**Re: C19-D011D9A Winklejohn Development, 7900 Carmel Avenue NE,
Permanent Certificate of Occupancy – Transportation Development
Engineer's Stamp dated 5-16-08 (C19-D011D9A)
Certification dated 6-03-08**

**Re: Winkel John Retail, 7900 Carmel Ave. NE,
Reject of Request of Permanent Certificate of Occupancy (C.O.)
Engineer's Stamp dated 08/13/07 (C-19/D011D9A)
Certification dated 4/26/08**

**Re: Winkeljohn Retail, Grading and Drainage Plan
Engineer's Stamp dated 8-13-07 (C19/D011D9A)**

**Re: Winkeljohn Retail, Grading and Drainage Plan
Engineer's Stamp dated 8-3-07 (C19/D011D9A)**

GRADING & DRAINAGE PLAN

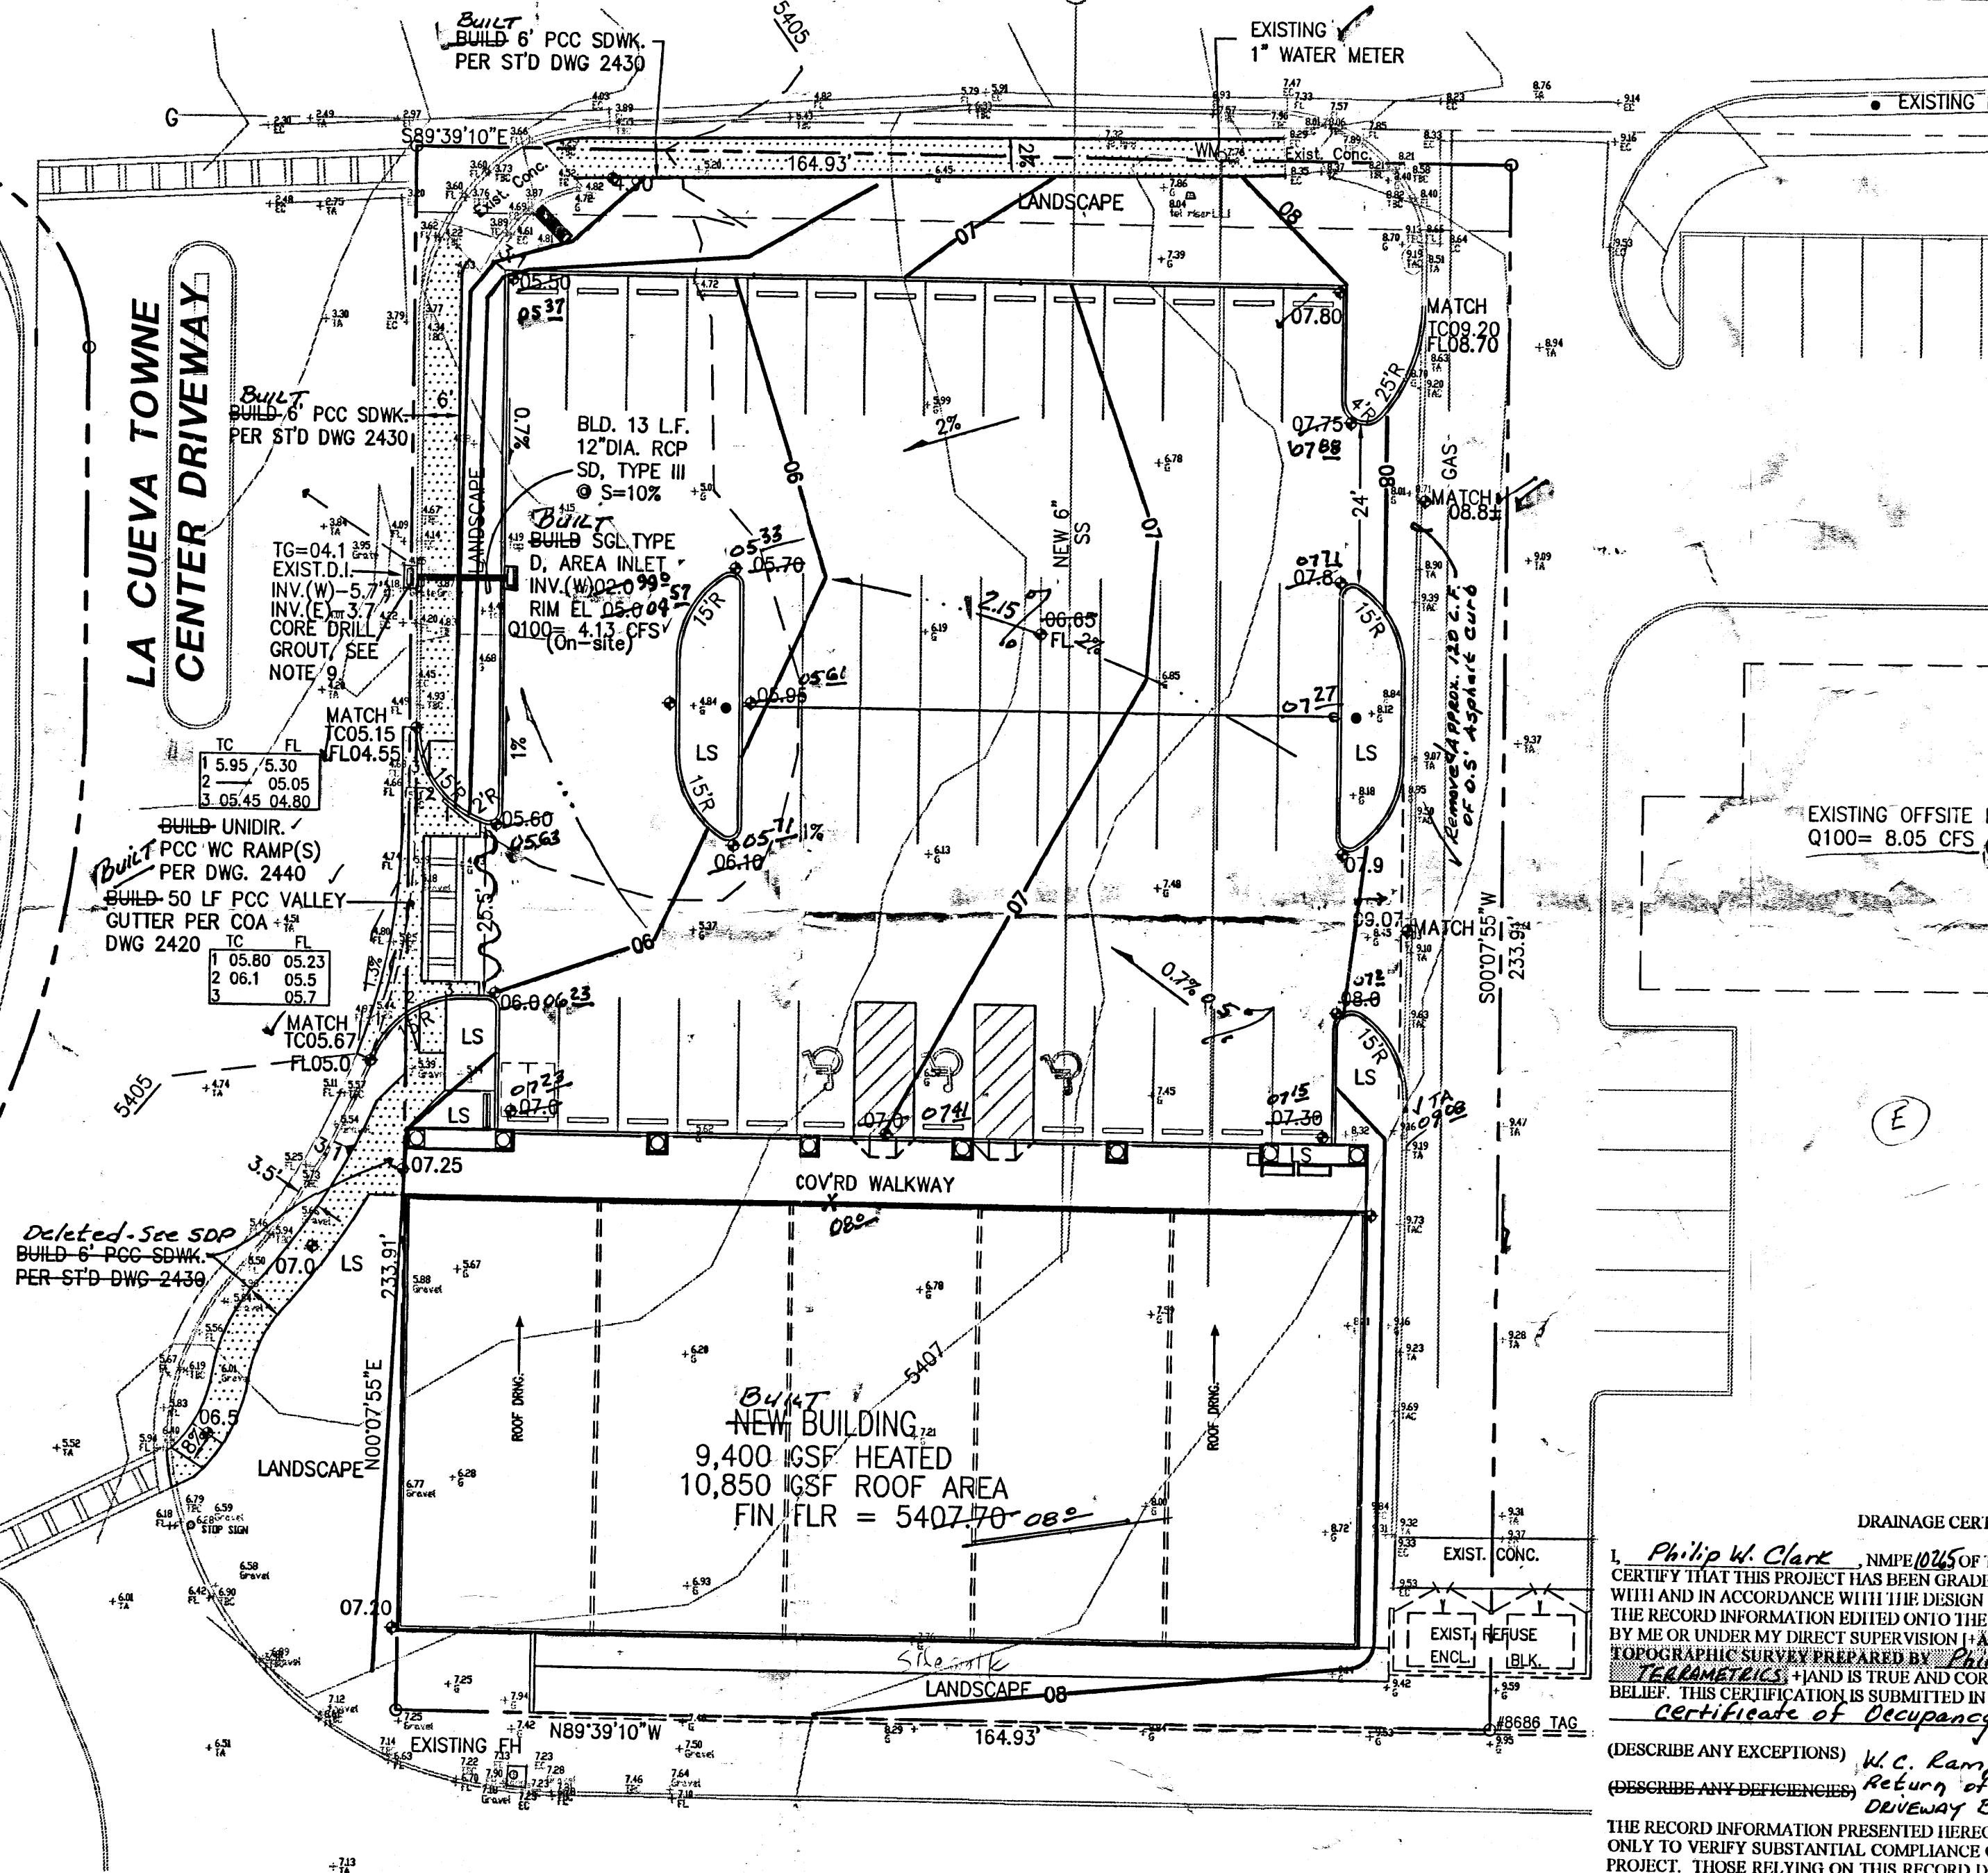
- The runoff from lots D, E, and F is supposed to enter the inlet in the private drive. Grading this site to drain to an inlet in this sites' parking lot and piping it to the back of the inlet in the private drive would help ensure that the runoff enters the storm drain system before entering Carmel Ave.
- Provide a build note for the size/type of curb to be built and where the existing curb is to be removed.

1 SITE PLAN
A1

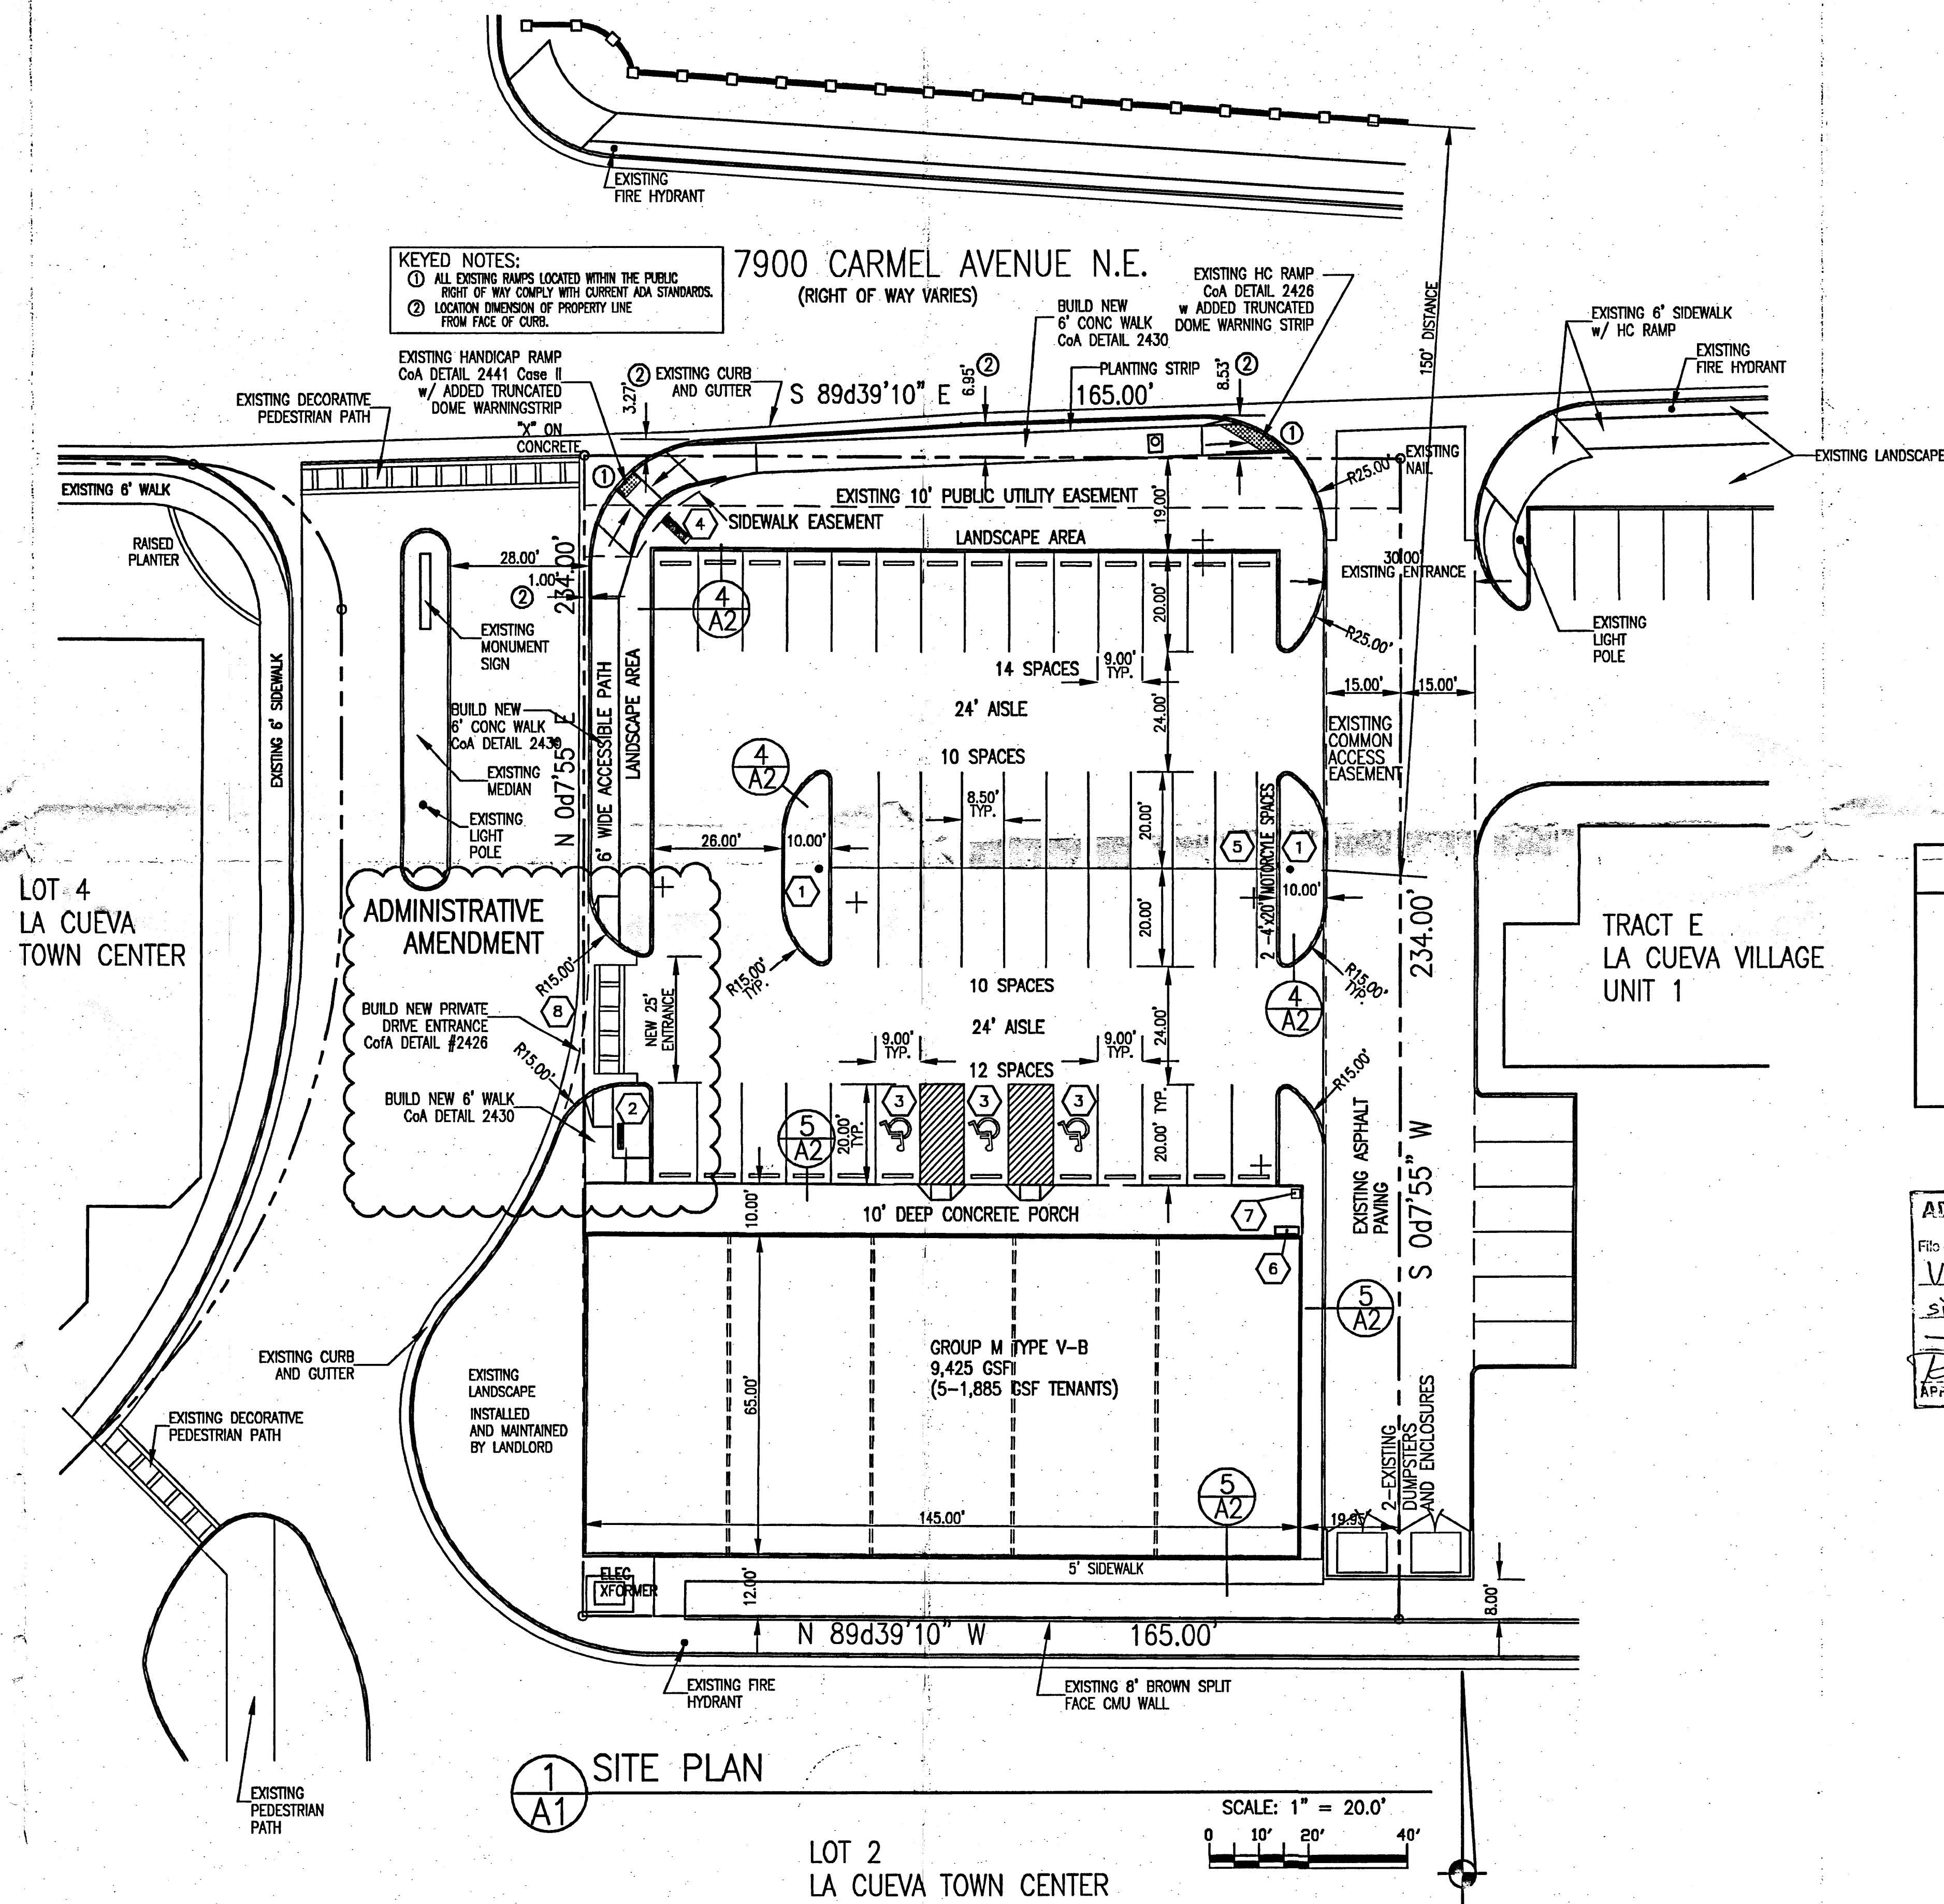
- Any changes to the approved plan must be redlined and initialed. The information shown on the submitted certification does not match what I saw on my last site visit.
- Your certification states that the owner and the shopping center have completed their negotiations that will allow the construction of the western curb cut. A copy of this agreement, signed by both parties, will need to be submitted for our files.
- A cross lot access easement is required.
- Based on previous discussions with the property owner, an administrative amendment should be done for this site. What is the status of this amendment?

1. Pending the approval of the Administrative Amendment to allow the drive-pad to the west access onto Carmel Avenue.
